Job ID: 2012-04-3759-CH OF USE

has permission to Create a Second Unit on the Second Floor of the Attached Garage (Two Family Residence).  
provided that the person or persons, firm or corporation accepting this permit shall comply with all of the provisions of the Statutes of Maine and of the Ordinances of the City of Portland regulating the construction, maintenance and use of the buildings and structures, and of the application on file in the department.

**Jonathan Rioux - 288 Eastern Promenade**

**From:** Jonathan Rioux  
**To:** Sheldon Ashby  
**Date:** 5/2/2012 2:33 PM  
**Subject:** 288 Eastern Promenade

2ND FLOOR PLAN

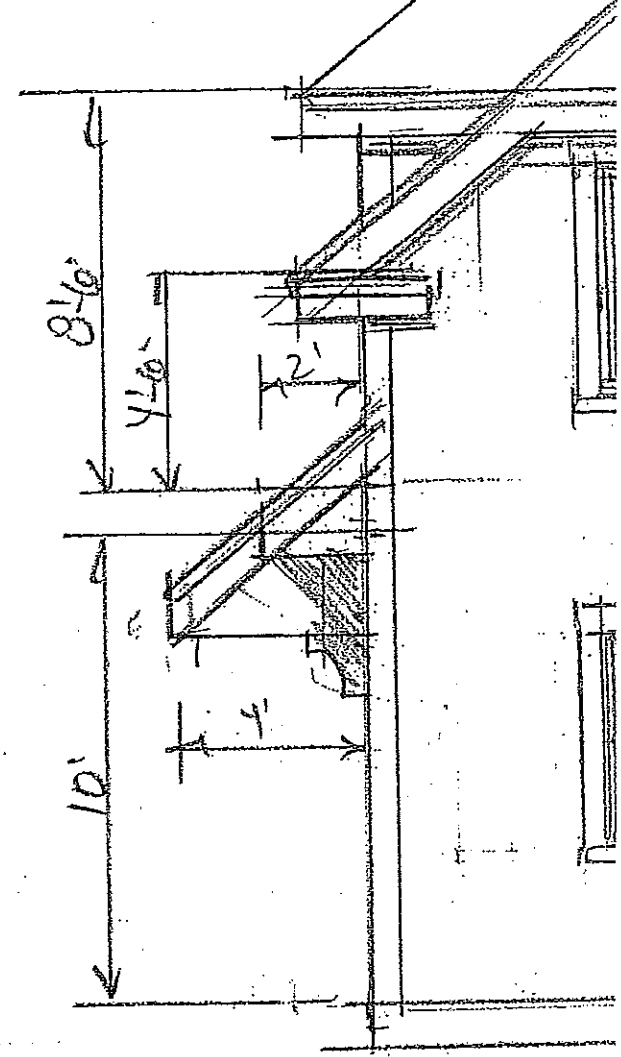
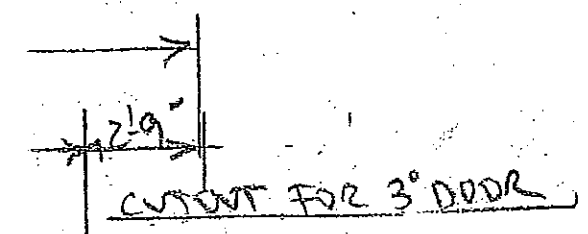
- A code compliant emergency escape shall be provided in **each bedroom**. Window sills in locations more than 72 inches from finished grade shall be a minimum of 24 inches (no higher than 44 inches) above the finished floor of the room, or in compliance with Section R612.4.2 Operation for emergency escape.

- Where are the bedrooms (Provide a Floor Plan)?
- A Carbon Monoxide (CO) alarms shall be installed in each area within or giving access to **bedrooms**. That detection must be powered by the electrical service (plug-in or hardwired) in the building and battery.

- Hardwired photoelectric interconnected battery backup smoke alarms shall be **installed in each bedroom**, protecting the bedrooms, and on every level.
